Appeal Decision

Appeal Ref: 6001667

112 Warwick Crescent, Hayes, Hillingdon UB4 8RQ

- The appeal is made under section 78 of the Town and Country Planning Act 1990 (as amended) against a refusal to grant planning permission.
 - The appeal is made by Nasir Butt against the decision of the Council of the London Borough of Hillingdon.
 - The application Ref is 22729/APP/2025/2325.
 - The development proposed is described as “Proposed ground floor single storey rear extension, part double storey side extension and part first floor rear extension and hip to gable end loft conversion with rear dormer and 3 no's skylight in front roof slope”.
-

Proposed Ground Floor Plan
Scale: 1:100

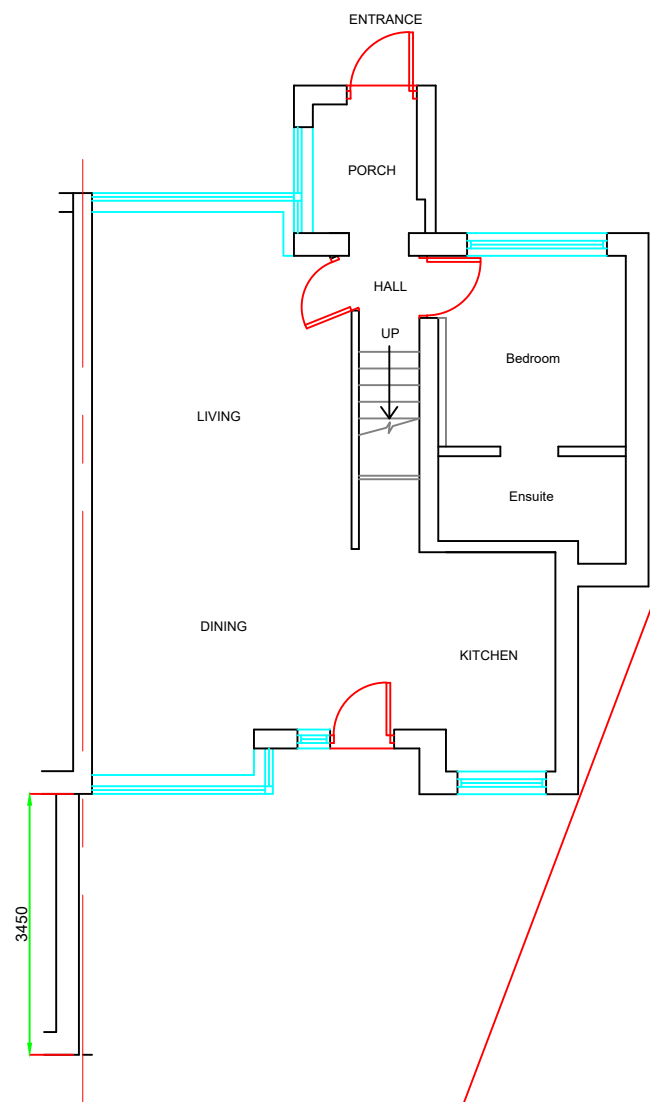
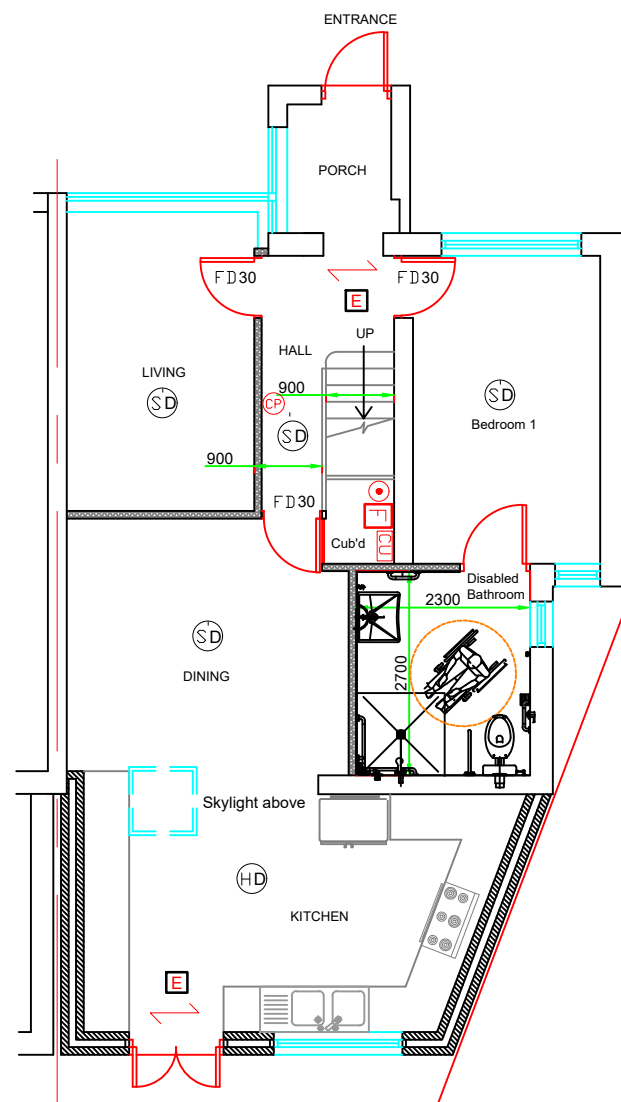
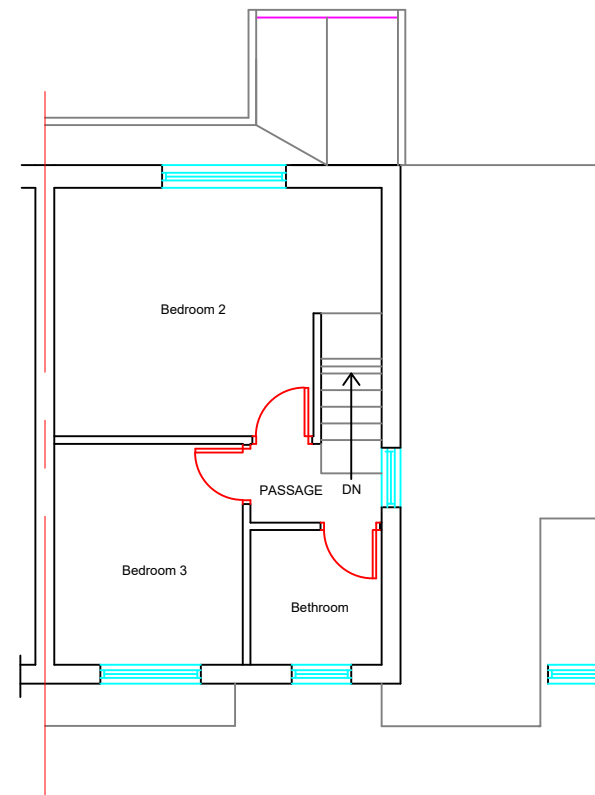
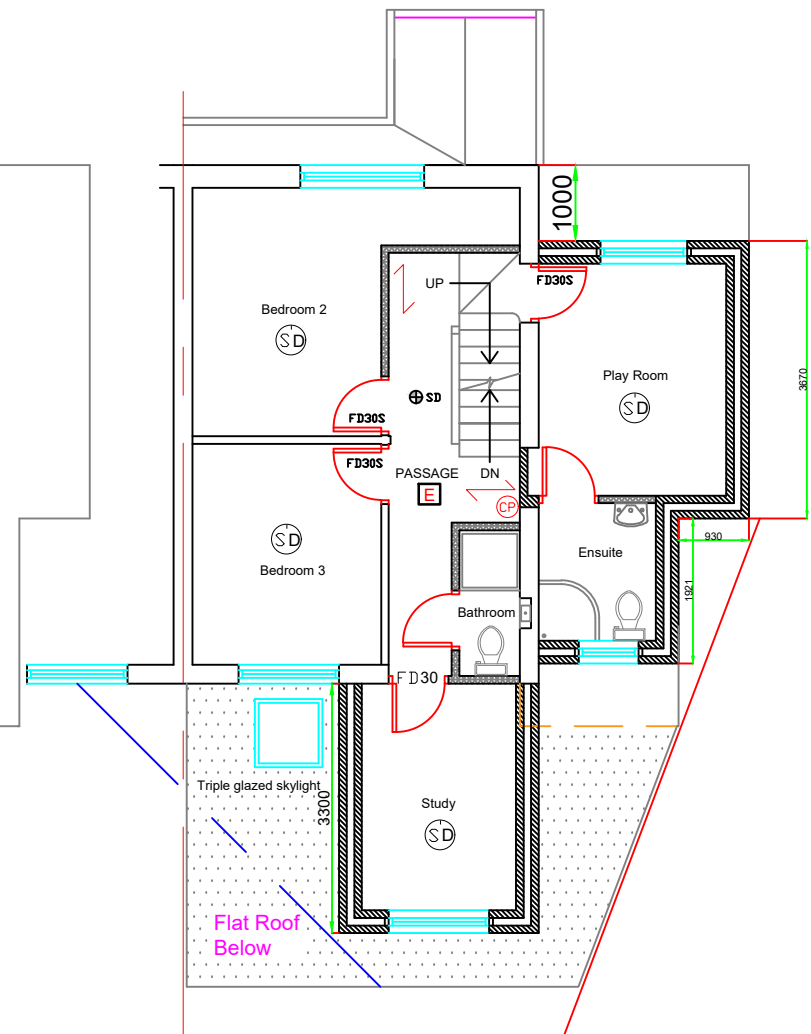
8. The proposed development would introduce a two storey side extension set back from the front elevation at first floor and set down from the main roof ridge. It would, in relation solely to the massing of the host dwelling, appear as a subordinate addition.

9. However, the proposal would result in a notable increase in the overall width of the appeal dwelling causing its bulk to appear prominently larger than the surrounding dwellings within Warwick Crescent, including its attached neighbour. Furthermore, the introduction of the two-storey side extension would result in a dwelling departing from the prevailing design of the surrounding properties. By virtue of its erosion of uniformity, the introduction of an incongruously massed dwelling, and the visual unbalancing of the semi detached pair, the proposal would harm the character and appearance of the area.

10. At the front elevation, the corner of the proposed side extension would be set away from the side boundary by 1 metre, which would accord with Policy DMHD1. Whilst I acknowledge the boundary's chamfer would result in this gap being reduced further down the side extension, the compact urban layout means that it would not be overly prominent and the existing spatial rhythm would be retained. Save for glimpsed views, the proposed side extension for the most part would appear suitably set back from the side boundary.

15. The proposed first storey rear extension would project from the rear elevation of the host dwelling by approximately 3.3 metres. Whilst it would be set back from the boundary, its height would result in additional prominent mass within the outlook of the rear windows of No 114, with particular regard to the ground floor due to their closer proximity. This would result in a loss of outlook for the occupants of No 114, eroding the existing outlook above the boundary fence and beyond that of what the extant permissions would provide. These conditions would be made acutely worse by the configuration of dwellings and the size of No 114's garden, which would result in the proposal appearing even more dominant.

16. Furthermore, the proposed first storey rear extension in cumulation with the two storey side extension would result in a dominant mass within close proximity to the boundary. The development would appear overbearing to the occupants of No 114 from their rear garden, particularly when using the area immediately to the rear of their house.
